**KIRKLEES METROPOLITAN COUNCIL
INVESTMENT & REGENERATION SERVICE**

DELEGATED DECISION TO DETERMINE PLANNING APPLICATIONS

Reference No:	2024/62/90461/W
Site Address:	Land at Occupation Road, Off Birkby Road, Birkby, Huddersfield, HD2 2ES
Description:	Erection of detached dwelling with detached garage
Recommending Officer:	Tom Hunt

DECISION – REFUSED

First Floor 163700
Ground Floor 161000

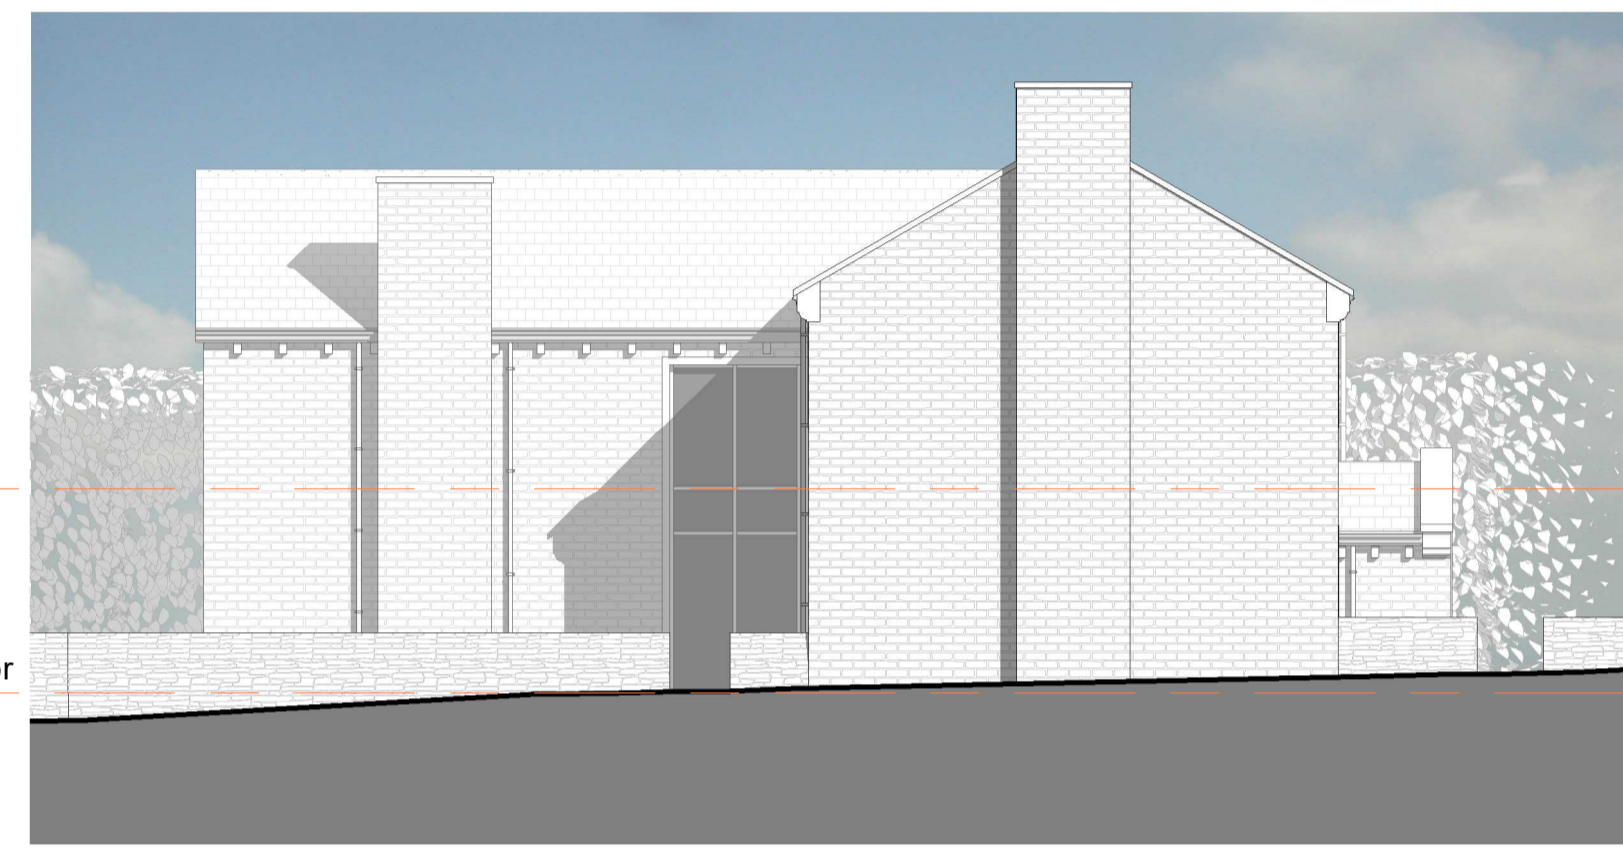
Further to this, with the plot being between the access track and No.1 Birchroyd Close, the width of the dwelling and the site would be noticeably smaller/narrower than properties in the immediate vicinity. In addition, it does not comply with Principle 6 of the SPD to have a 2m gap to flank boundaries nor would appear to be in keeping with those properties emphasising the dwelling as an alien feature in the streetscene.

The dwellinghouse would appear to have a roofline appearing in keeping at front however the extended rear projection would appear dominant and out of scale with the main body; this design would have its flank elevation/roof design highly visible, even above the hedging, and intrusive to the local character of its locality. The proposed materials and fenestration to the front of the host and to the garage appear high quality and in keeping with the locality

however the proposed fenestration at the host's rear and side introduces significantly uncharacteristic extents of glazing out of keeping with the area. The proposed boundary treatment of drystone wall are acceptable and would delineate between public and private realm. To ensure a high quality landscaping arrangement for visual amenity and biodiversity, this could be conditioned, should the proposal be otherwise acceptable.

In relation to No.1 Birchroyd Close, the proposed development would extend 15m in depth, be two storeys and be sited in close proximity to the shared boundary which has hedging and a tree nearby. The height of the hedging is 5.5m however the close siting of the development may harm the longevity of the hedging and tree.

There would be two bathroom windows to side elevation at first floor with potential half window views of the neighbour's garden separated by 16m to the rear elevation of no.1's conservatory complying with Principle 6. If the proposal was otherwise acceptable, Officers recommend that this be conditioned as obscurely glazed to maintain the privacy of both neighbours given the close distance to no. 1's boundary and garden and in the event that the hedging may be reduced either by damage to roots or removal/pruning. There is a lower level, first floor shower room window within the rear projection which would have very restricted views, this is also recommended to be obscurely glazed for the same reasons. The other windows on the ground floor would serve a landing and utility room and the separation distance would comply with Principle 6 of the SPD in this respect and their uses would not require obscure glazing even considering the possibility of the hedging to be removed. Given its distance and position west of no. 1, subject to condition, under a finely balanced assessment, it is considered that the proposed development would not cause undue harm to No.1 in terms of loss of light, loss of outlook, overshadowing or the creation of an overbearing effect in the event of the green screening being removed.

**2** South Elevation  
Scale - 1 : 50

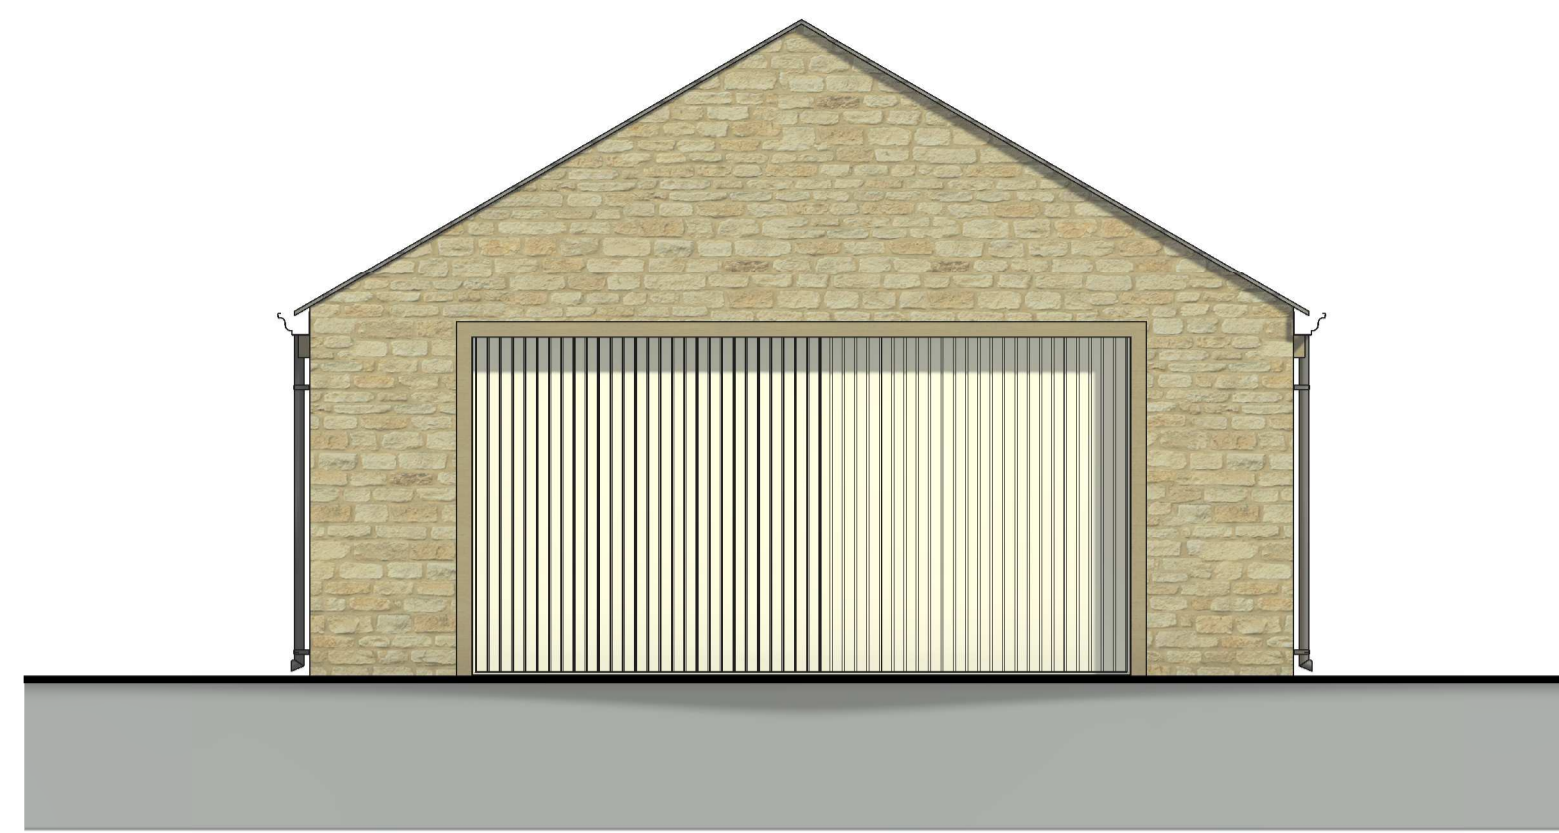
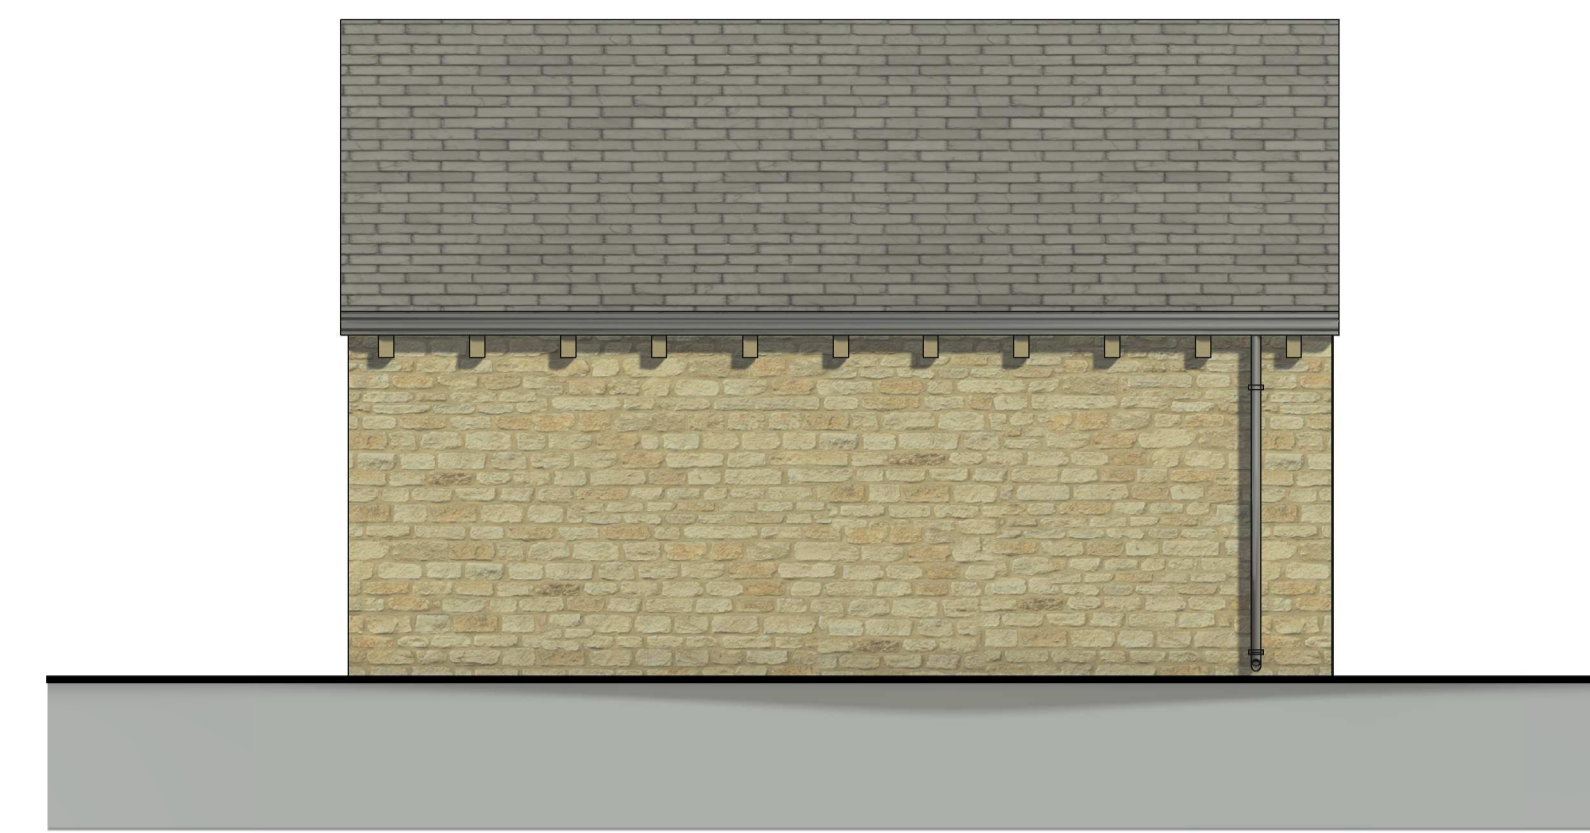
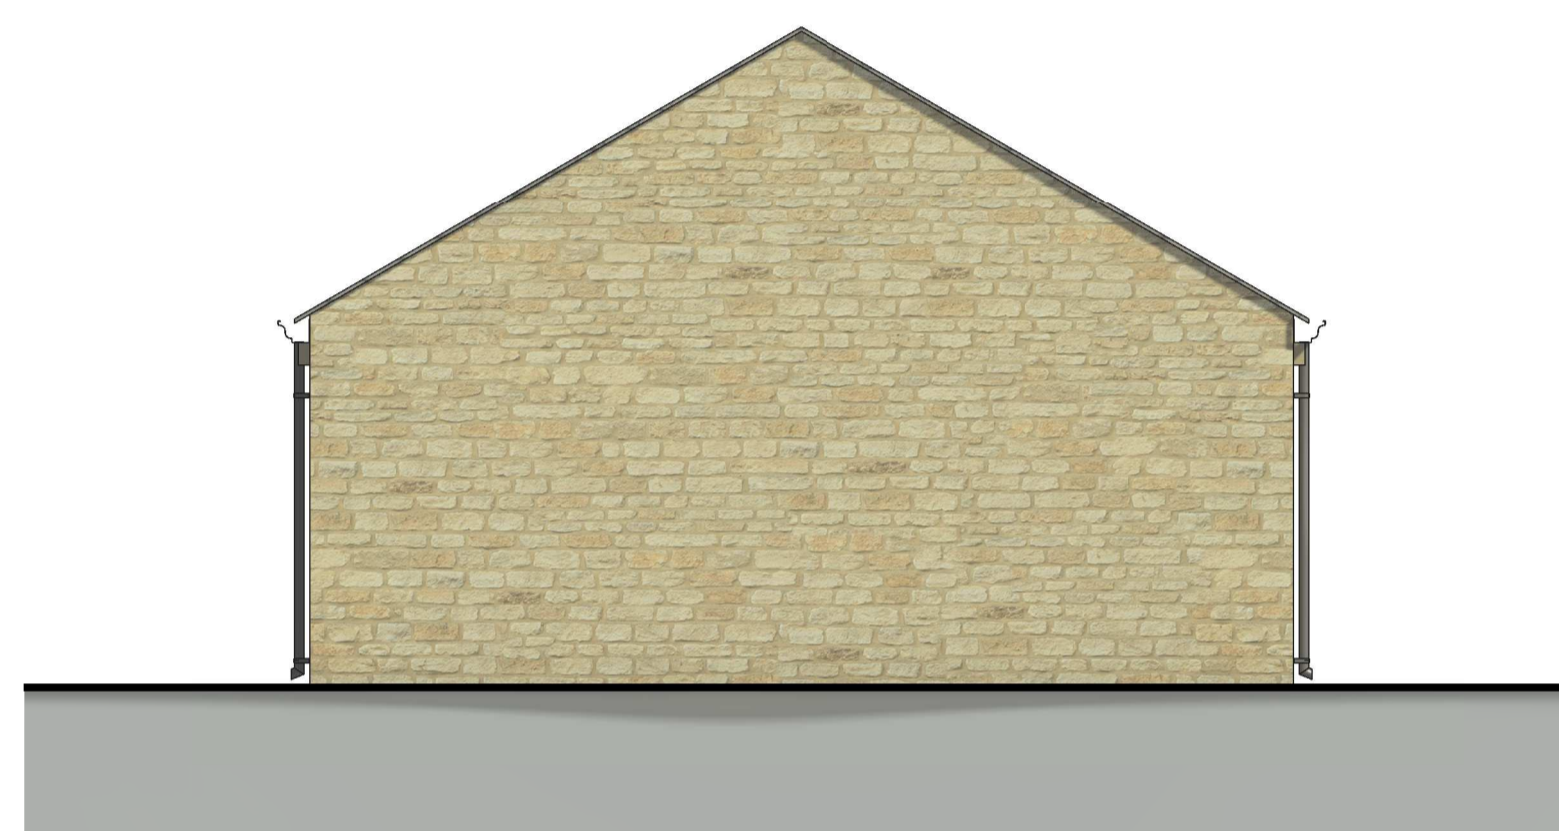
For both no.s 3 and 5, views from the rear section of glazing at (internal) first floor level for the bedroom, would be presently screened by the hedging at a height of 1.7m with a limited section of 40cm at the top of the glazing and also the neighbouring trees, which would appear adequate to preserve privacy and avoid overlooking to the neighbours and their private gardens. The closest tree to the rear window is deciduous and would have leaf fall annually

That said, Officers have concerns with the level of privacy that would be enjoyed by the occupants of the proposed property, especially given the expanse of glazing to both storeys of the rear elevation exposing living and bedroom arrangements, in the event that the green screening be removed or die back. As such, the proximity of glazing and the dwellinghouse to no. 3’s rear garden would provide an unsatisfactory level of privacy for both no. 3 and the future occupiers.

It is therefore considered, that the proposed dwelling, by virtue of the close proximity of the proposed rear glazed section to the private rear amenity space of no. 3 Birchroyd Close, would cause undue harm in terms of loss of privacy and overlooking. In addition, the close relationship of no. 3 Birchroyd Close to the proposed dwelling with extensive glazing to living quarters on both storeys in having a limited level of privacy, thereby having a harmful impact upon residential amenity contrary to Policy LP24b) of the Kirklees Local Plan, Principle 6 of the Housebuilders Design Guide SPD and Chapter 12 of the National Planning Policy Framework.
